**Re: APS Arroyo Del Oso Elementary School at 6405 Harper Dr. NE
Erosion and Sediment Control Plan
Engineer's Stamp Date – 1/20/2023 (E18E007A)**

Based upon the information provided in your submittal received 8/18/2023, the above referenced ESC Plan can't be approved until the following comments have been addressed.

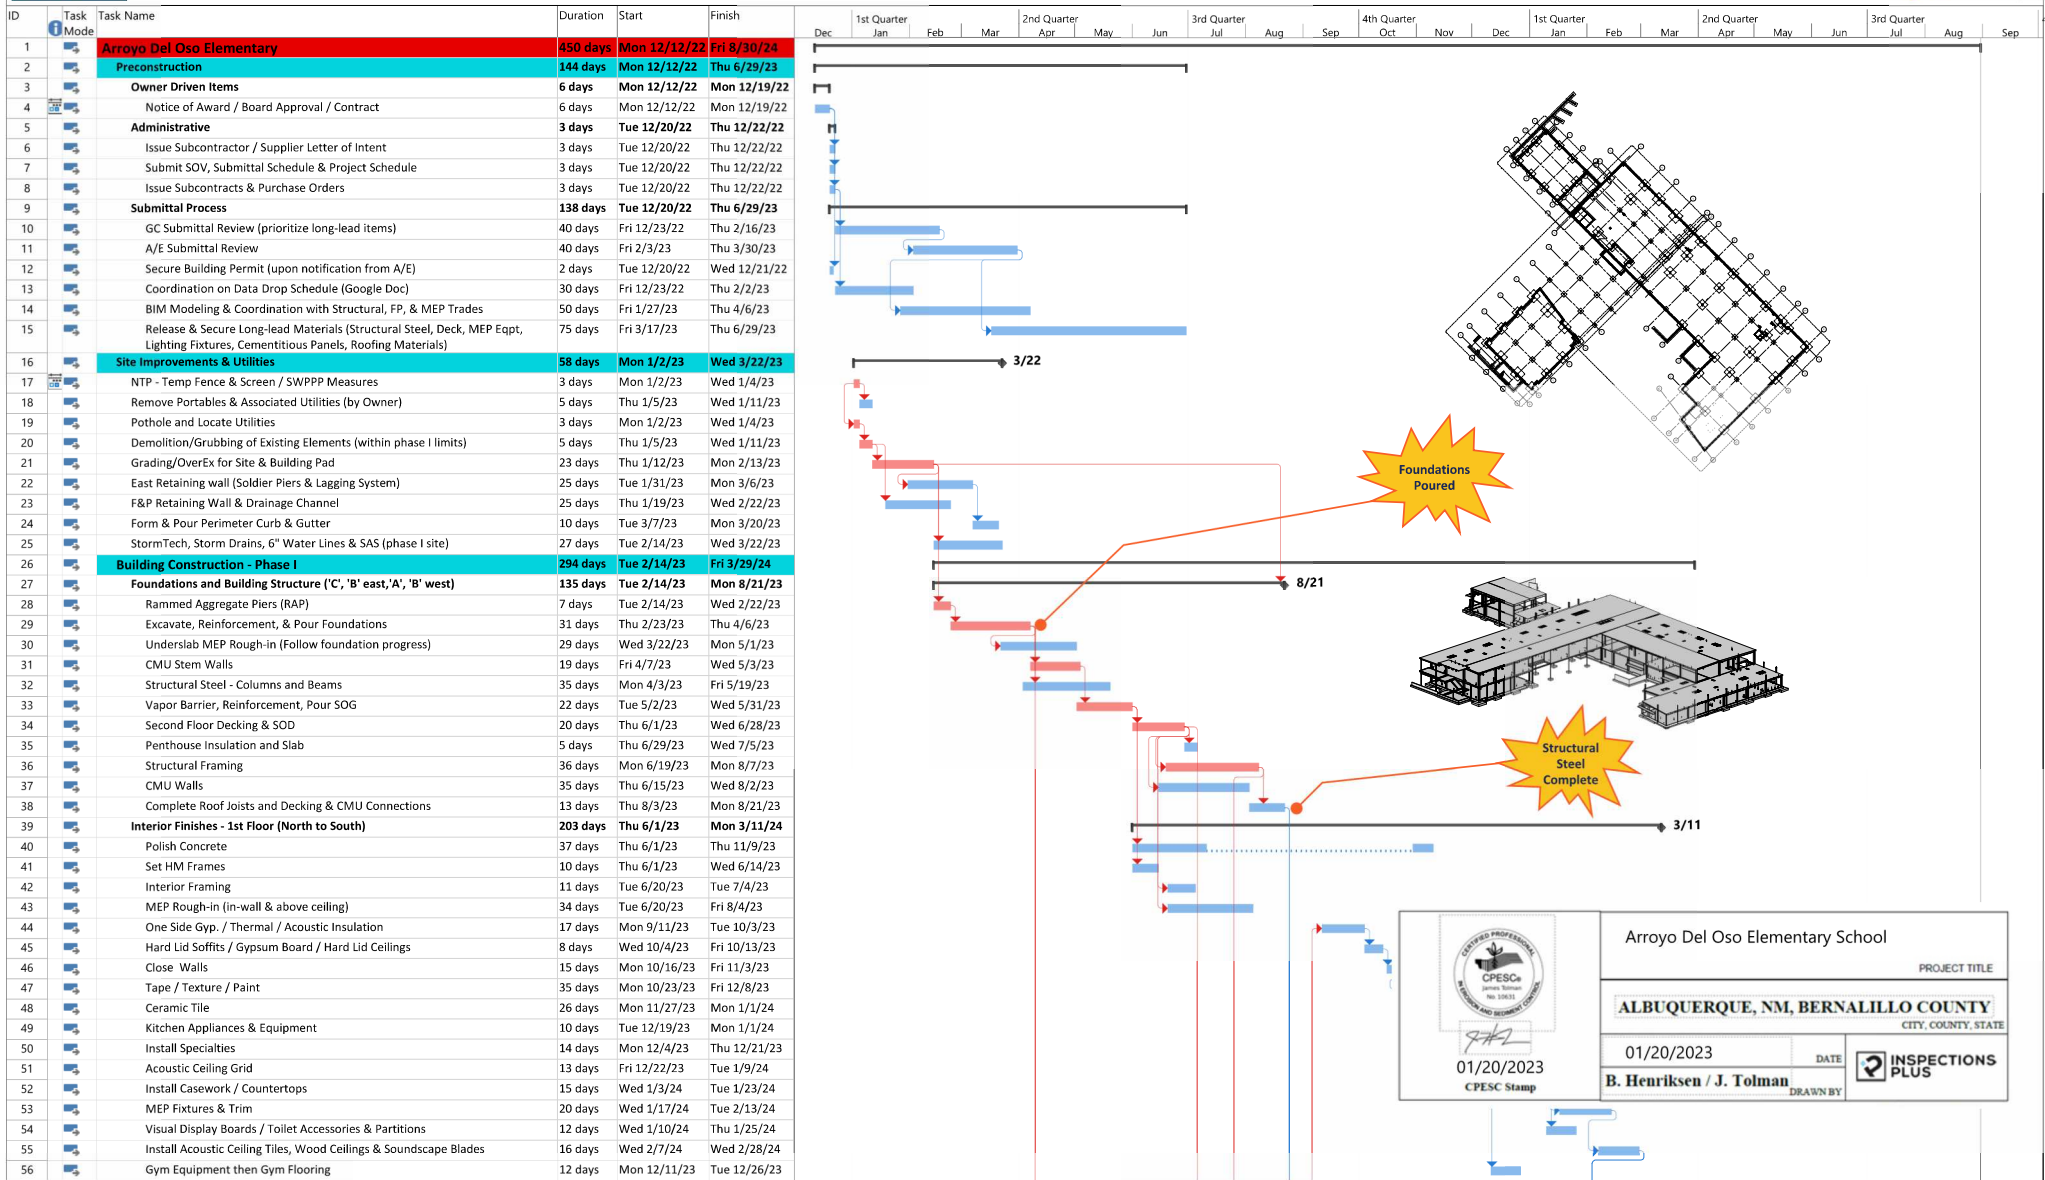
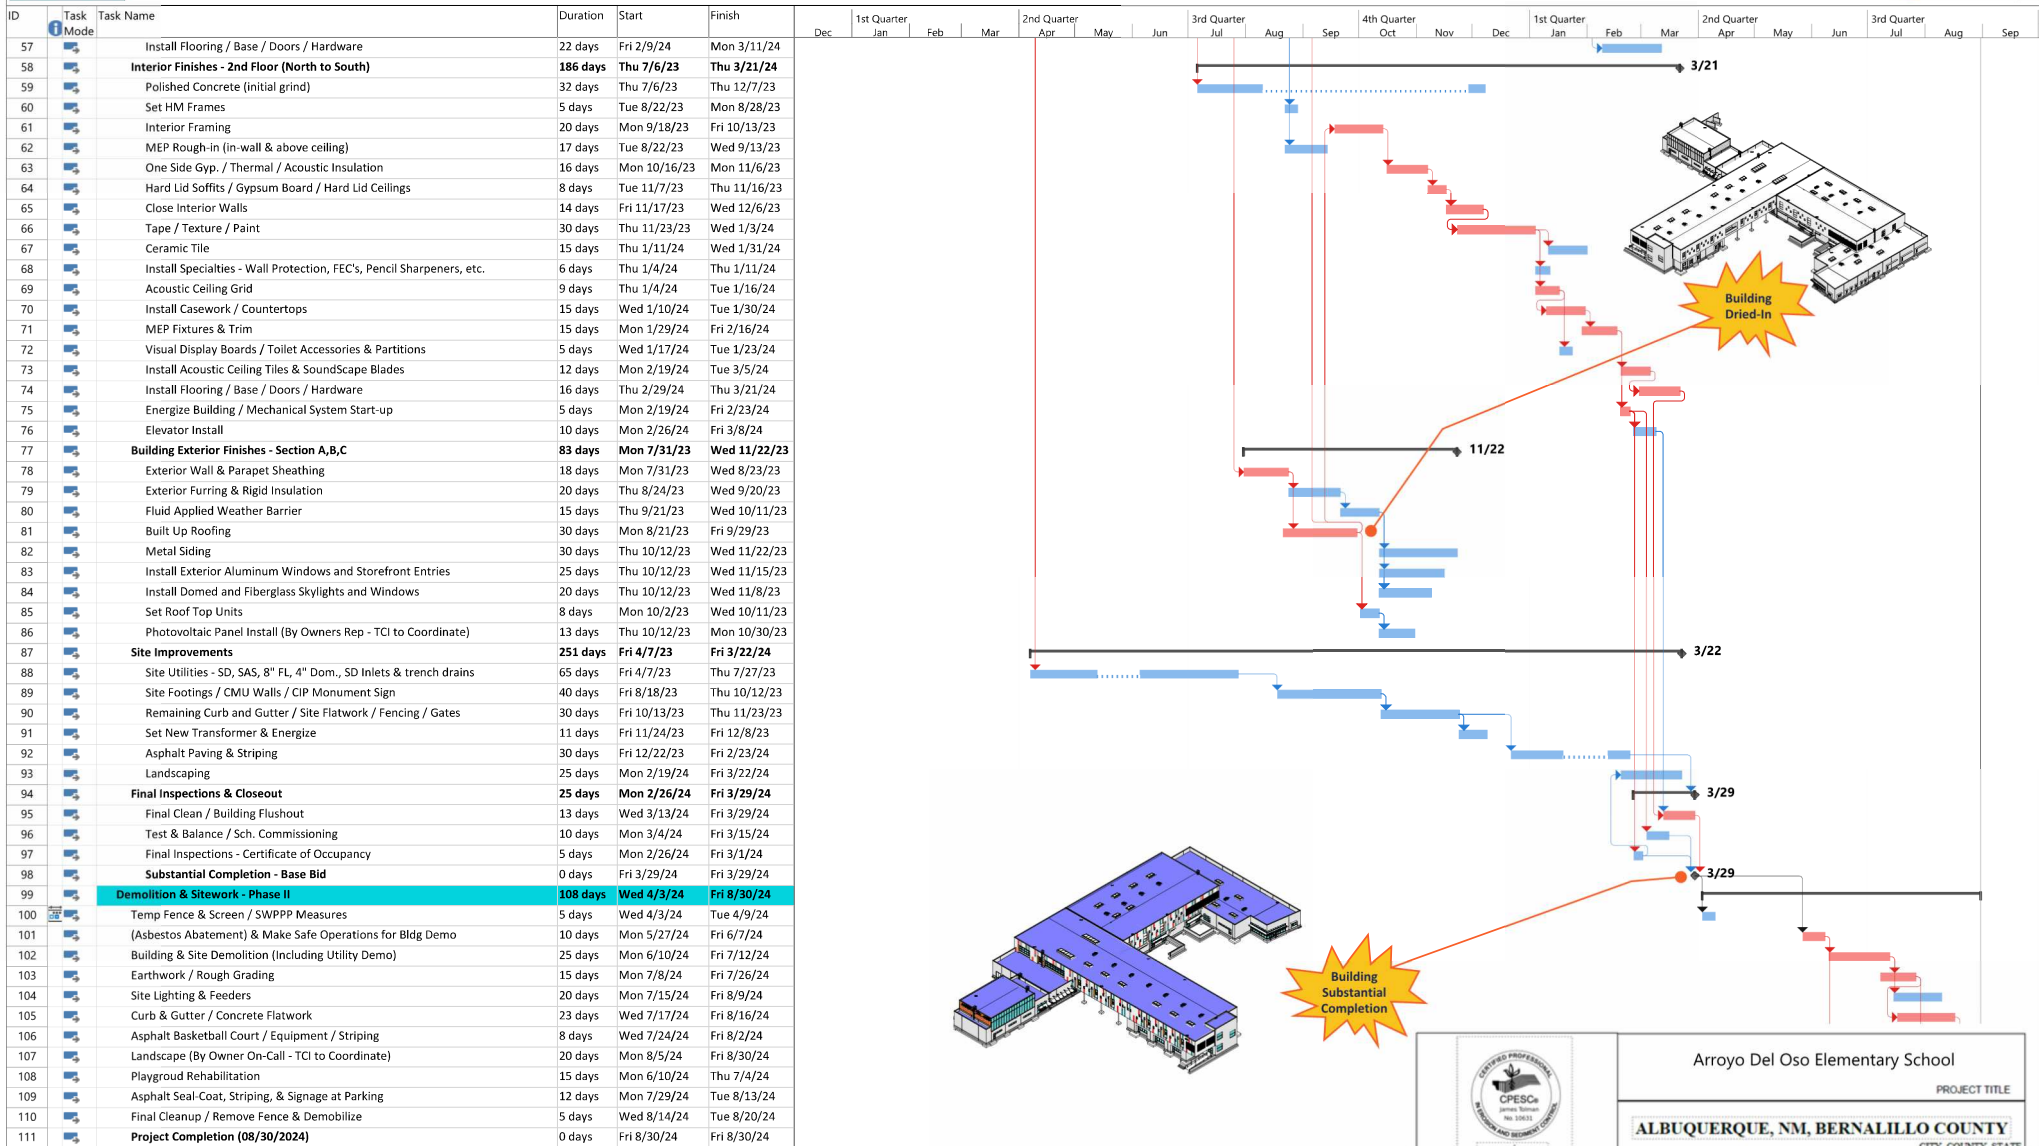
1. The ESC plan isn't legible, symbols and lines are fuzzy and just get more blurry when I zoom in so the controls, limits of disturbance, and property boundary are not readily discernable. Clearly locate and identify all of the required elements of the map. Clearly indicate the location and type of the planned controls upstream of the primary outfall channel on the west side of the property.

4. It isn't clear which erosion controls will be constructed prior to phase 1 and 2 and how long the controls will last before they are removed. Include a detailed schedule on the ESC plan for each control, especially final stabilization.
